Gilbert C. LaForce, P.E.
El Paso County
Planning and Community Development
2880 International Circle, Suite 110
Colorado Springs, CO 80910

RE: Cloverleaf TIS Response to Comments

Kellar Engineering (KE) comment responses in **blue** font.

## School Pedestrian Routing to Lewis Palmer High School (0.2 miles)

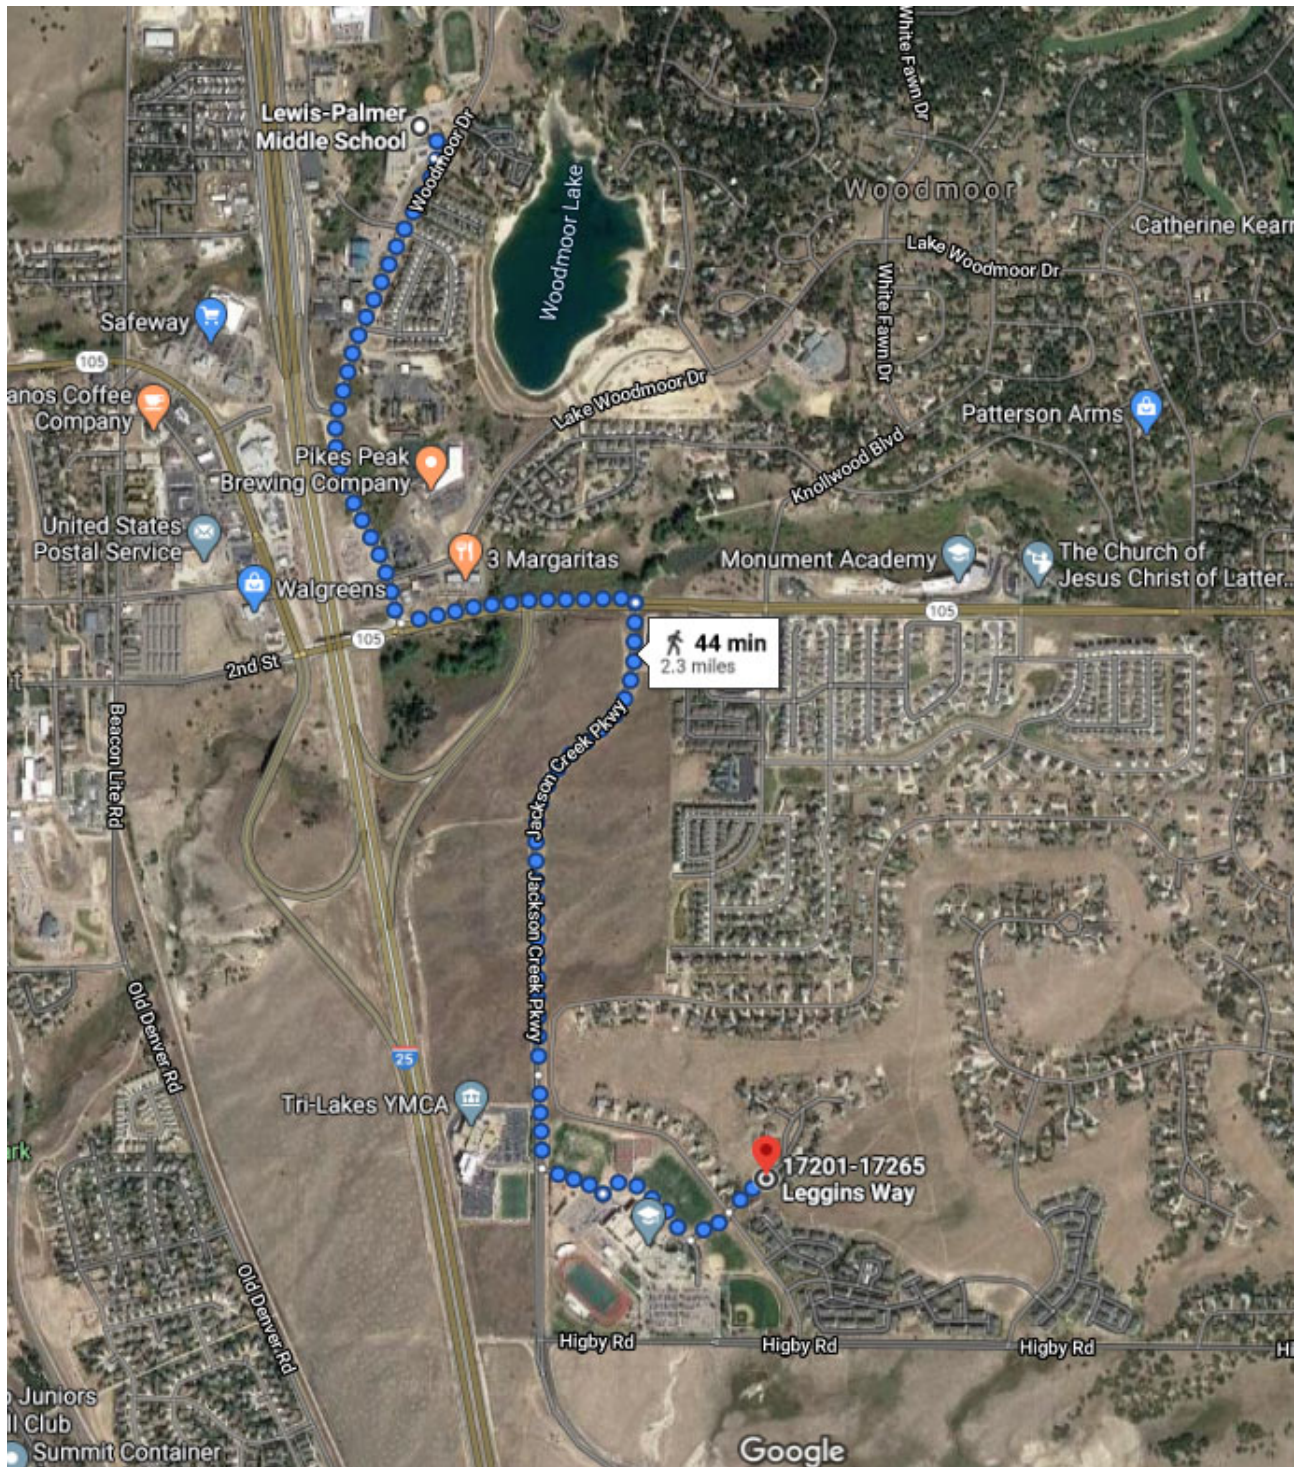
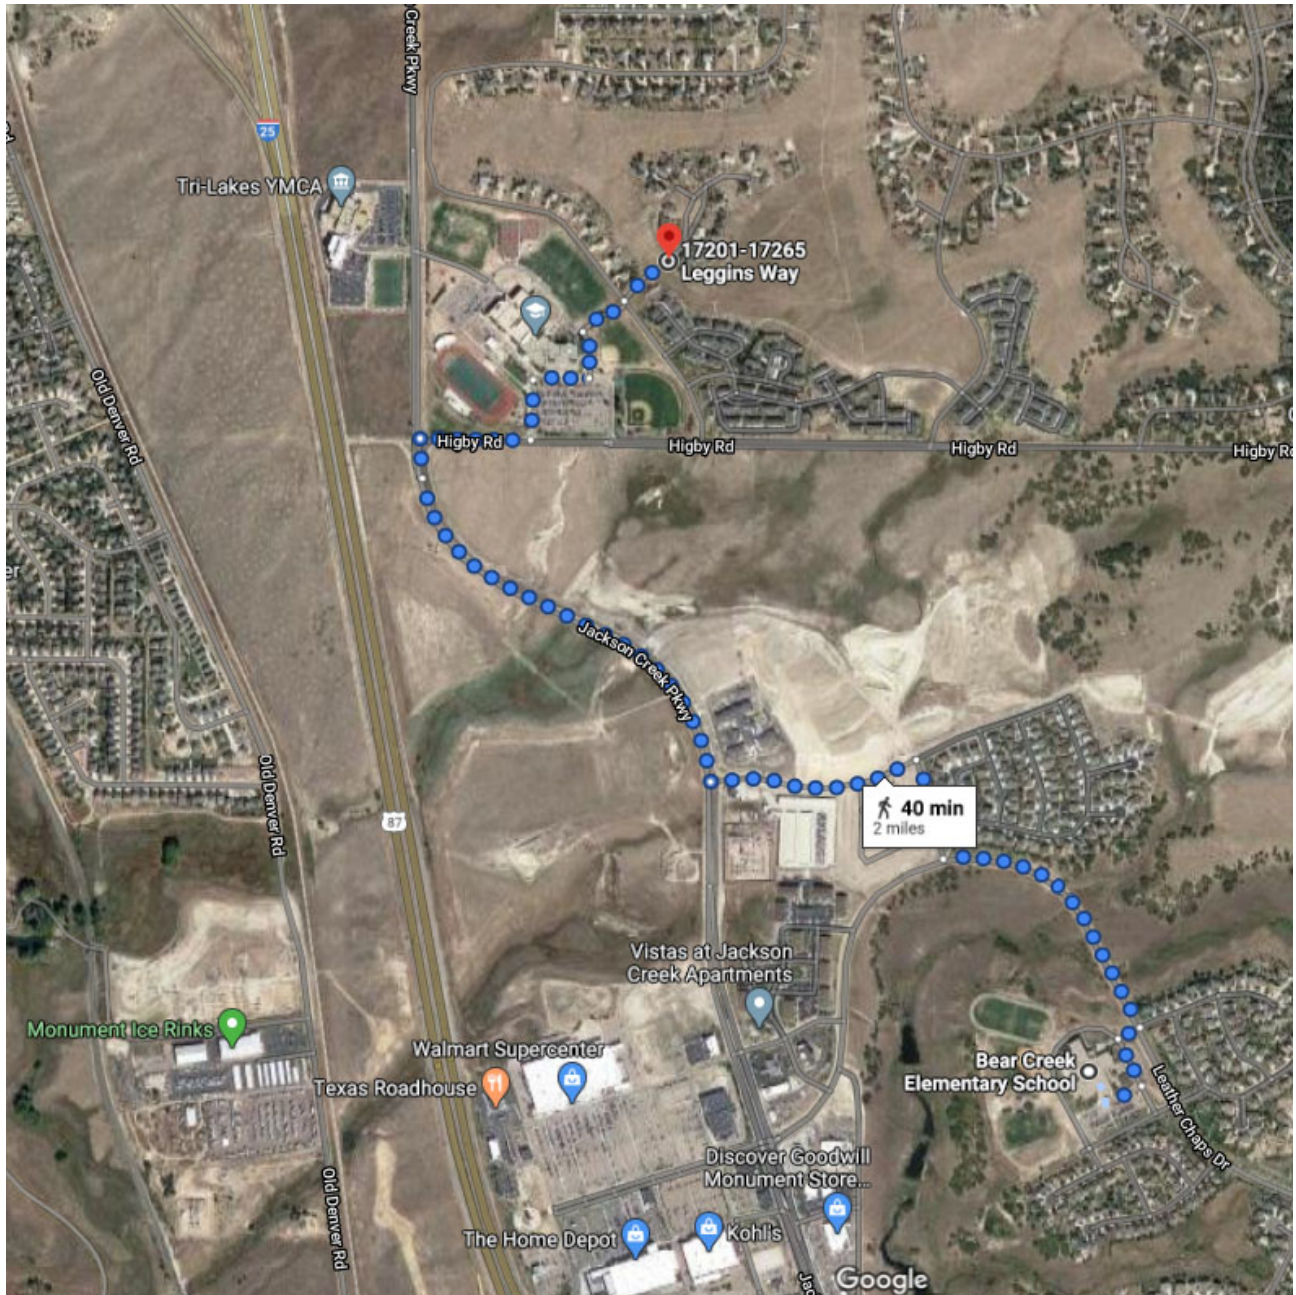
11. Comment. Add a section analyzing pedestrian routes to schools within 2 miles of the project (Lewis Palmer High School, Lewis Palmer Middle School, Bear Creek Elementary School) and recommendations for traffic control devices or on-site/off-site improvements. Include an exhibit showing school locations in the vicinity of the project.

Response. See Section 4.6 and Appendix C in the updated TIS.

Appendix E: Sight Distance

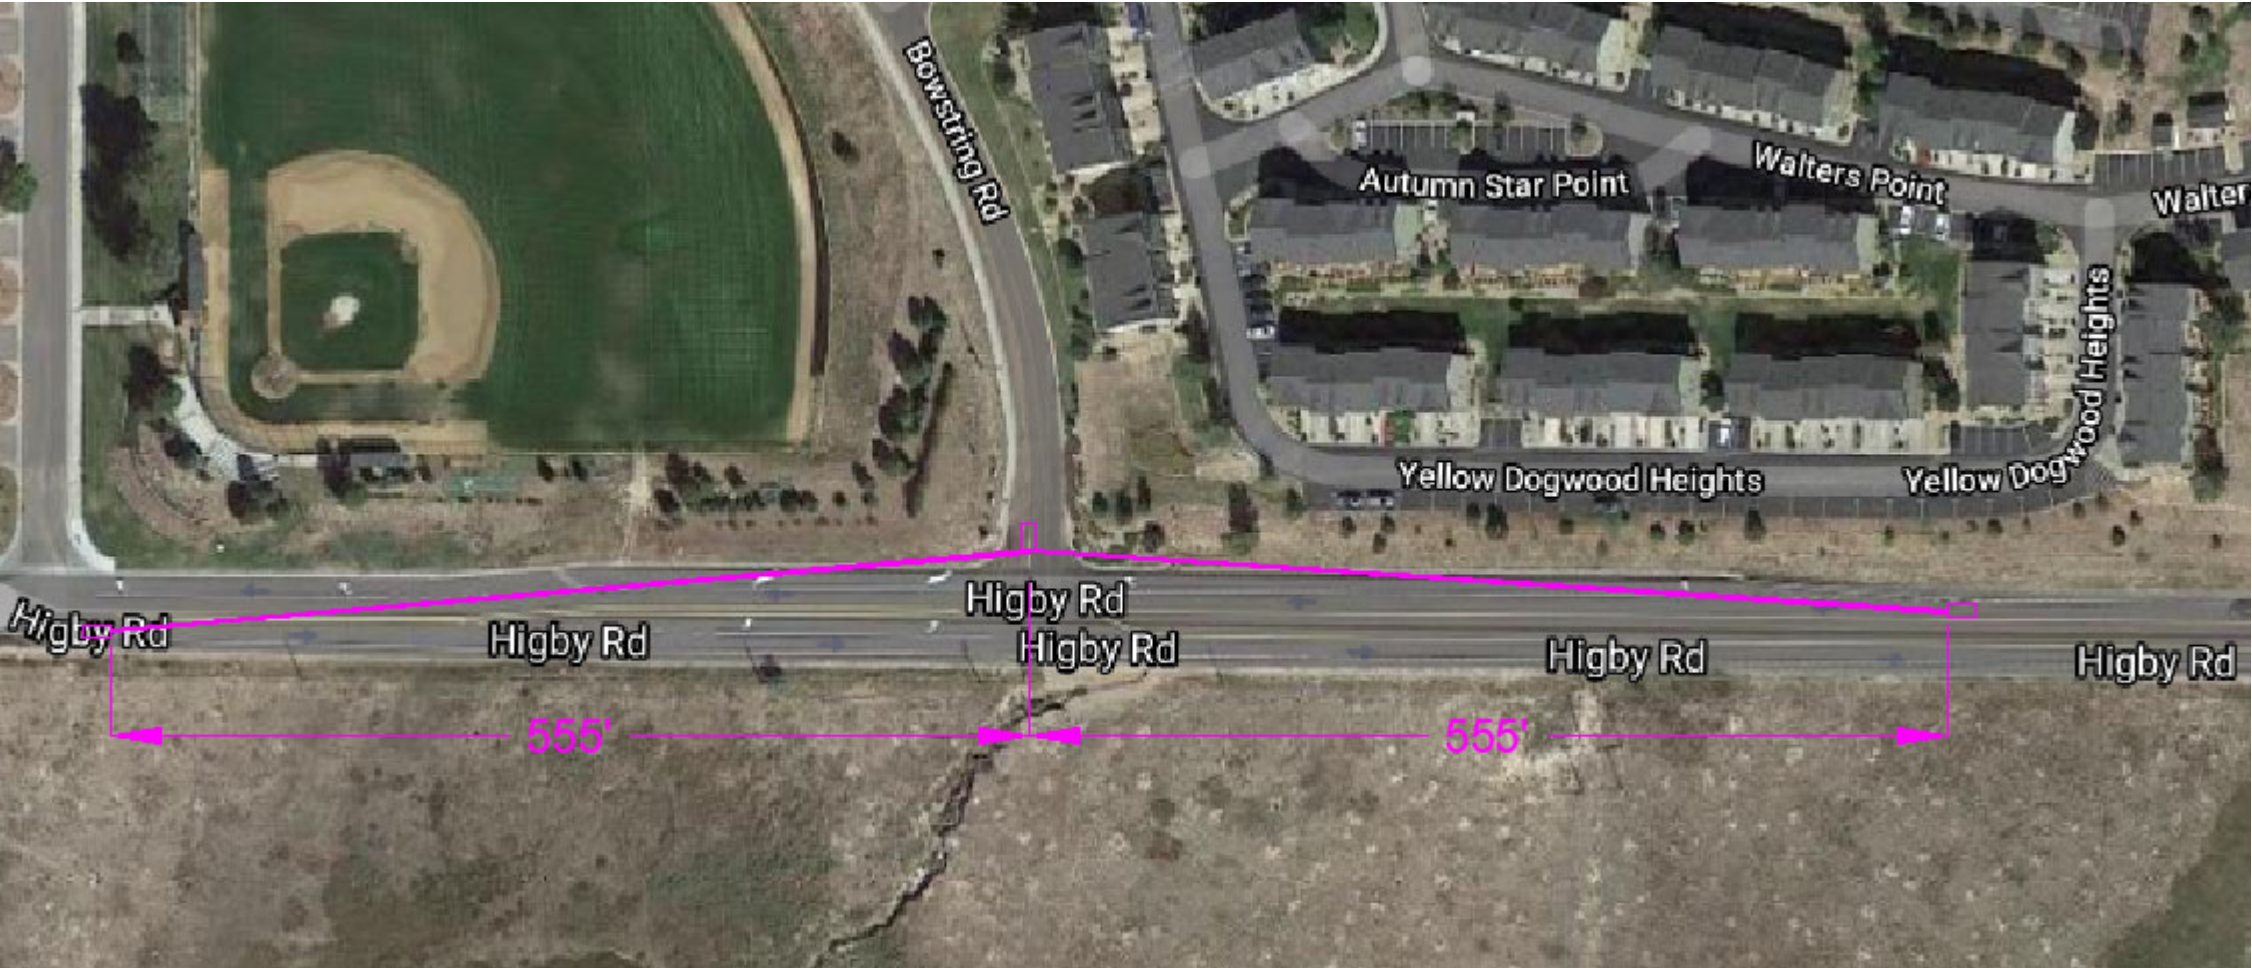
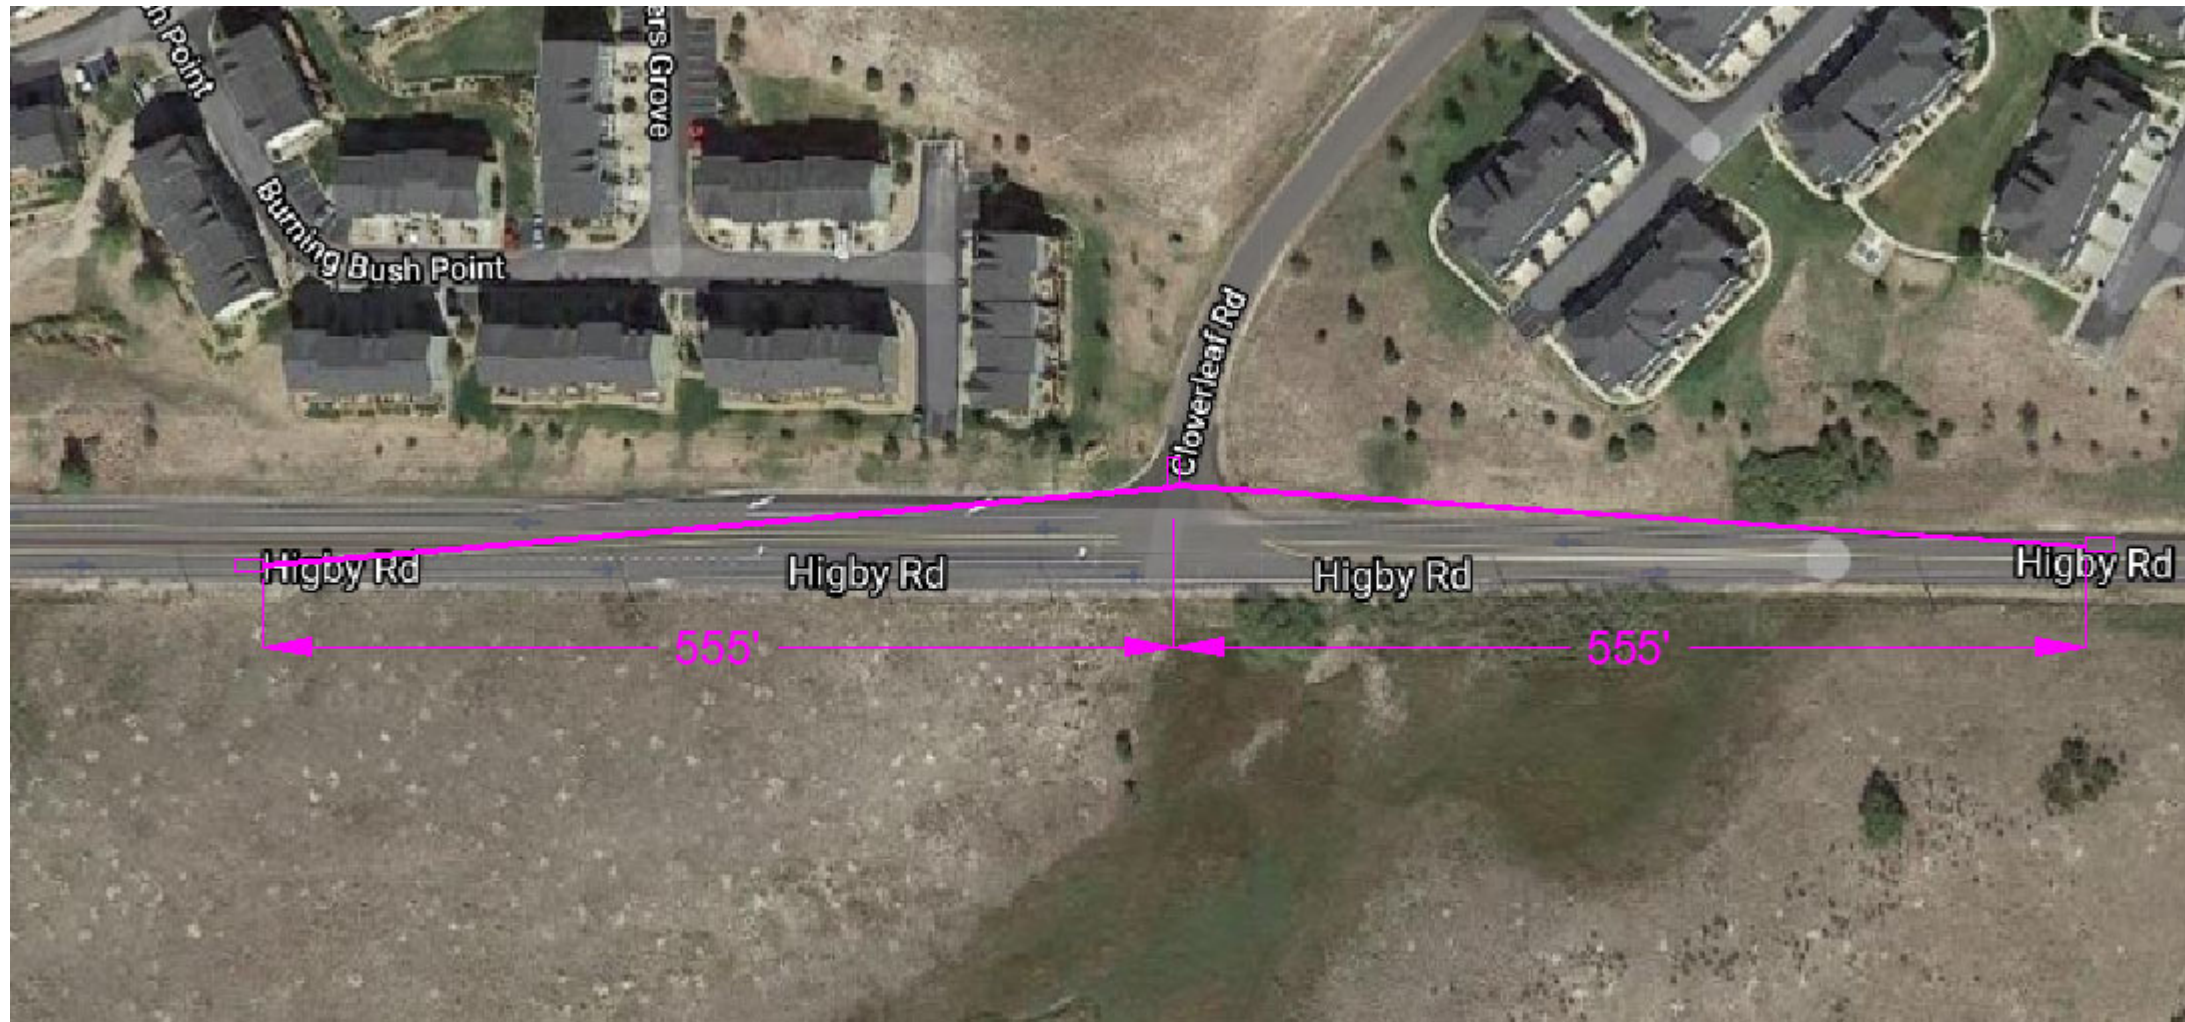
10. Comment. Add section for sight distance analysis/recommendation at the proposed access locations. Include an exhibit showing the sight distance.

Response. See Section 4.5 and Appendix E in the updated TIS.
